Response to Planning Application

Application ref: M/92/21/PL

Description: Demolition of existing bungalow & construction of 1 No 2-storey dwelling with access & off road parking. This site is in CIL Zone 4 & is CIL Liable as new dwelling.

Location: 68 Ancton Way Elmer Middleton-On-Sea PO22 6JP

PROPOSED PLOT PLAN

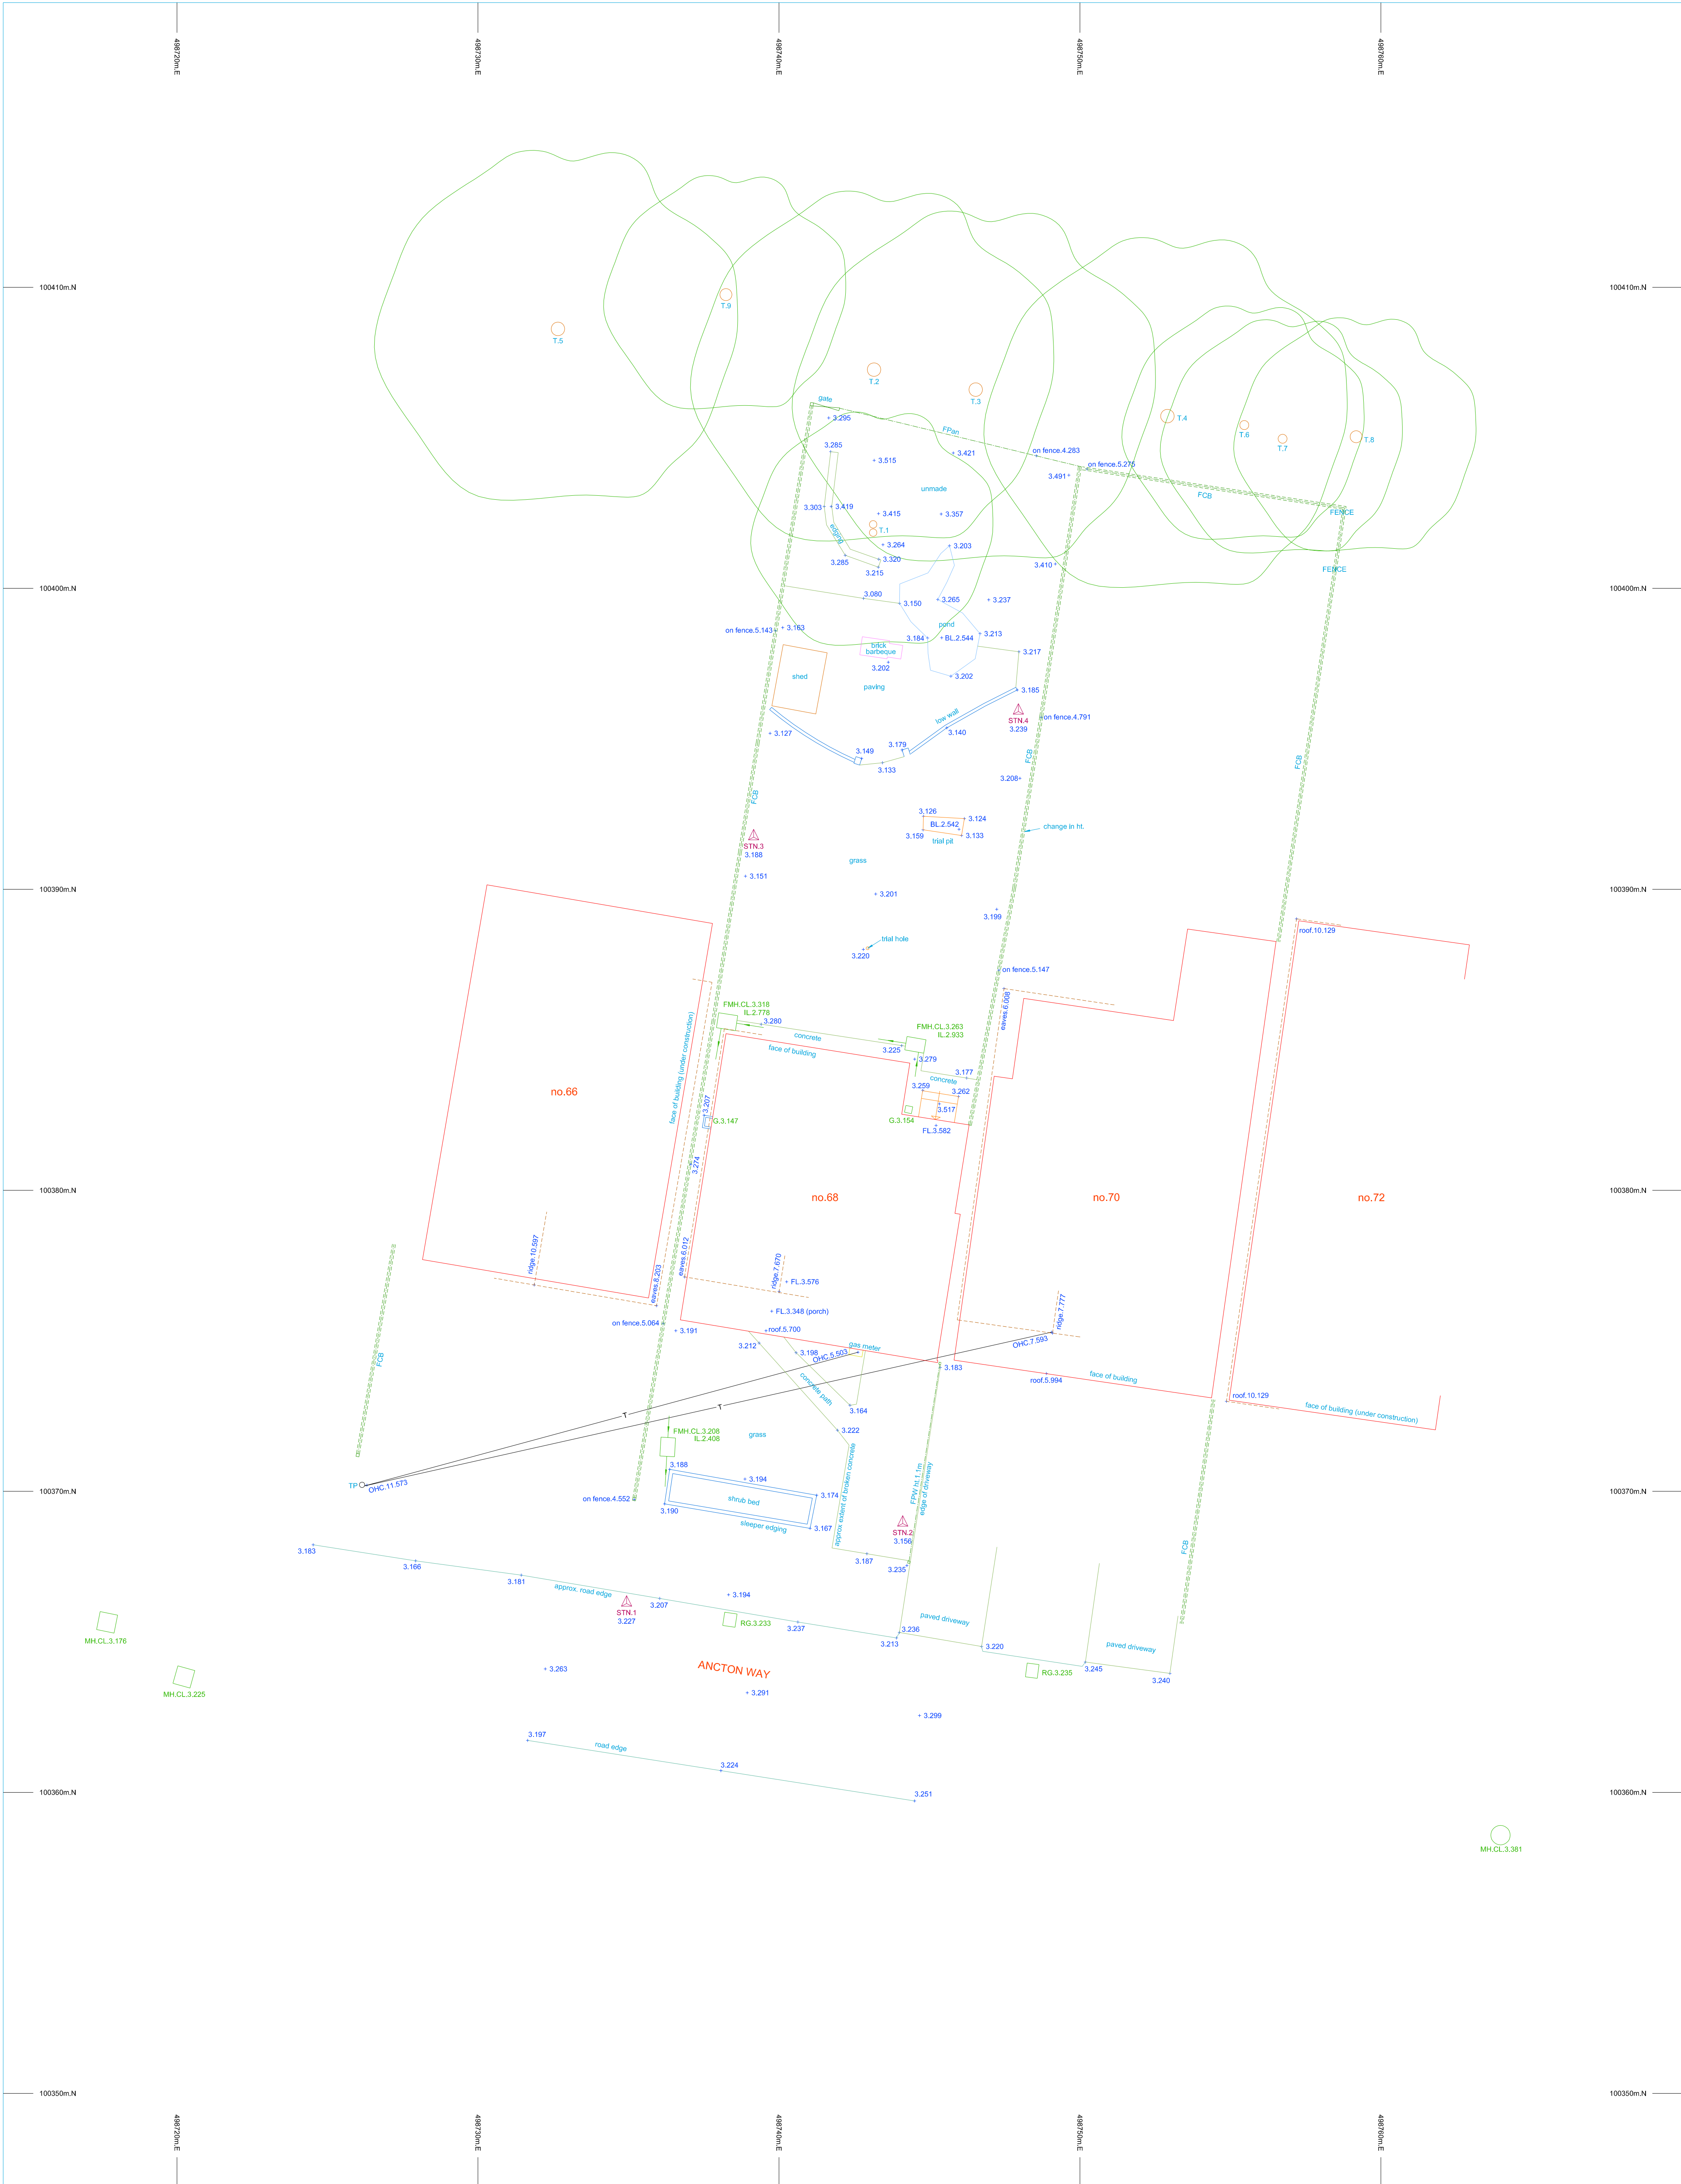
The NPPF para 124/127 relate to good design principles which equally apply to small infill and replacement development. The indicative site layouts show no tree protection plans or indicative planting alongside tree

retention. These details would require expanding in the form of a detailed planting plan and specification detailing species choice, actual plant quantities, planting densities and size at time of planting. Detail should also be provided regarding existing trees and boundary planting where appropriate..

I would recommend no landscape objection to the proposals subject to submission of landscape details to provide ornamental and native improvements and potential biodiversity gain.
